Lime Down Open Floor Hearing 1

2.00pm - 21st April 2026

Good afternoon, I am Lawrence Copeland and I am speaking on behalf of Grittleton, Sevington & Leigh Delamere Village Hall Charity. I am a trustee of said Charity.

I would like to provide more detail to our written submission where we registered our objection to the proposed Lime Down project.

Title:
Figure 13-12 Construction Access Locations:
Cable Route Corridor

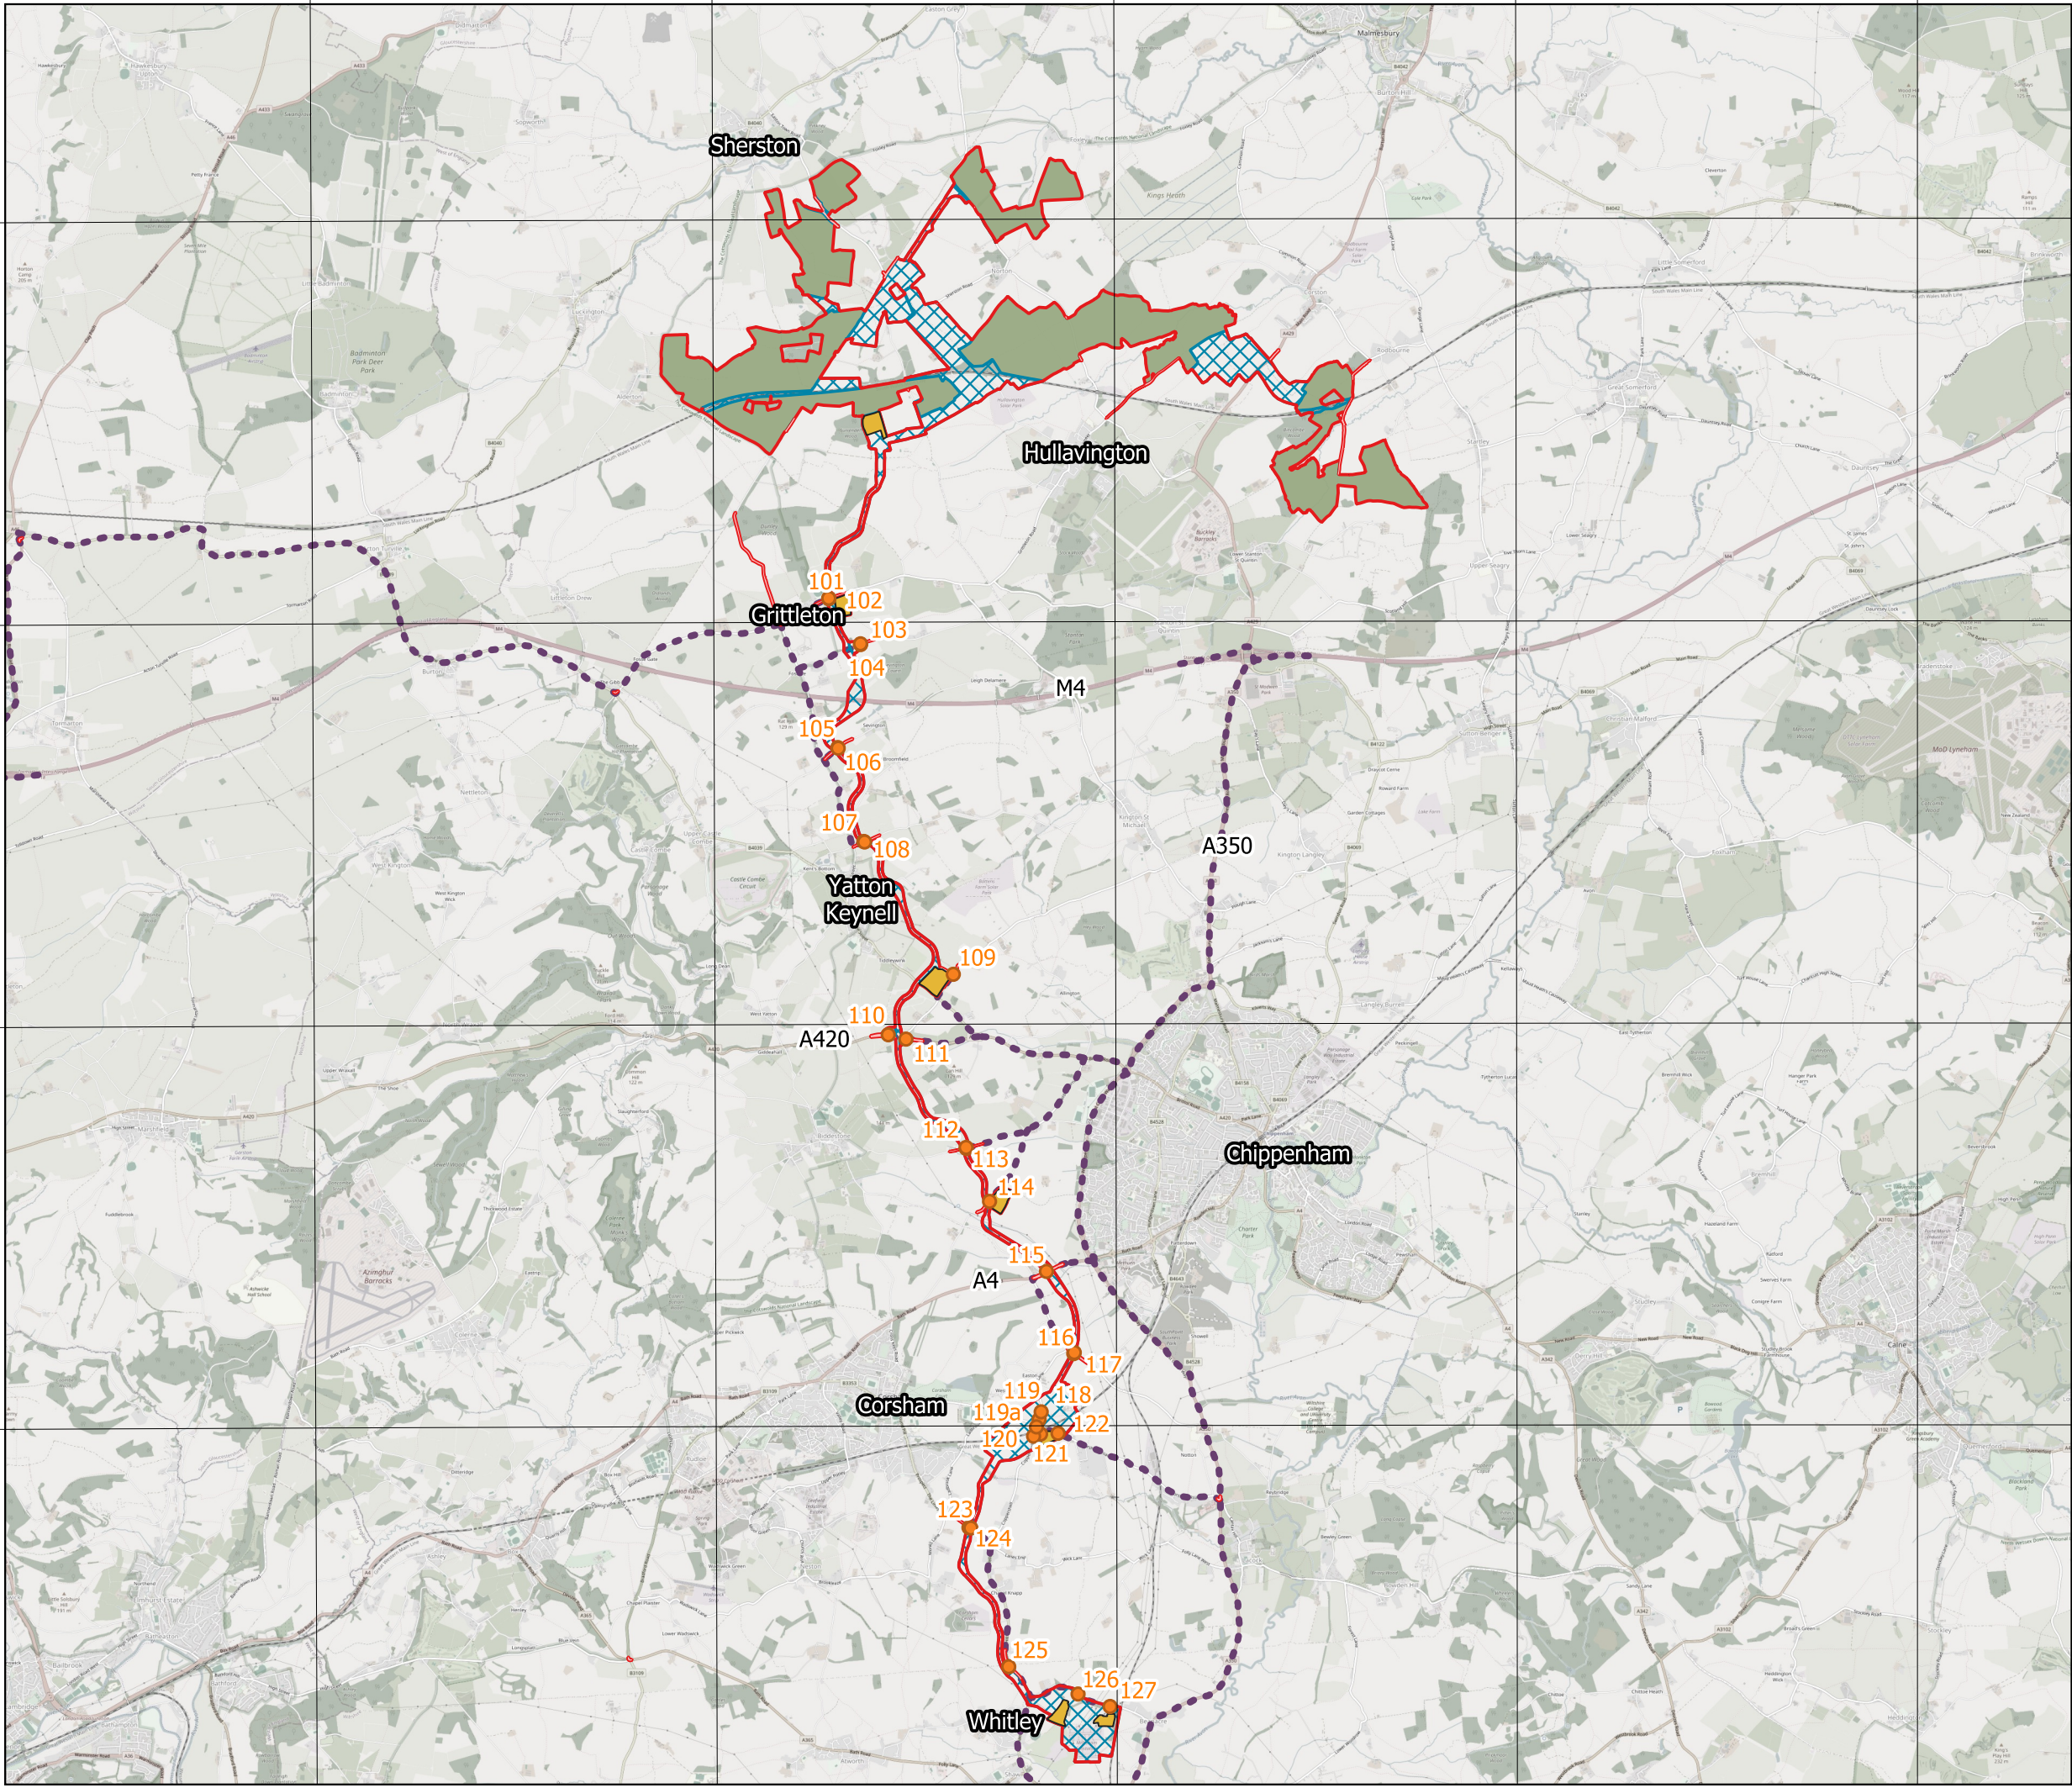
The proposed cable route will pass the eastern edge of Grittleton. According to the Outline Construction Traffic Management Plan, there will be two Access Points (Ref 101 & 102), plus a construction compound leading off from Access Point 102.

The Village Hall is 75 meters from these Access Points, our children's playground is 36 meters away.

Our main hall, where recreational classes are held, is 16 meters from the road leading to these entrances, the children's playground is next to it.

With two access points, there will be 32 movements of HGV/LGV plus 40 of cars or vans, slowing down or speeding up as they pass our Hall and playground, each **day**.

This does not include the number of vehicles required to construct and decommission the compound, I couldn't find anything covering that.
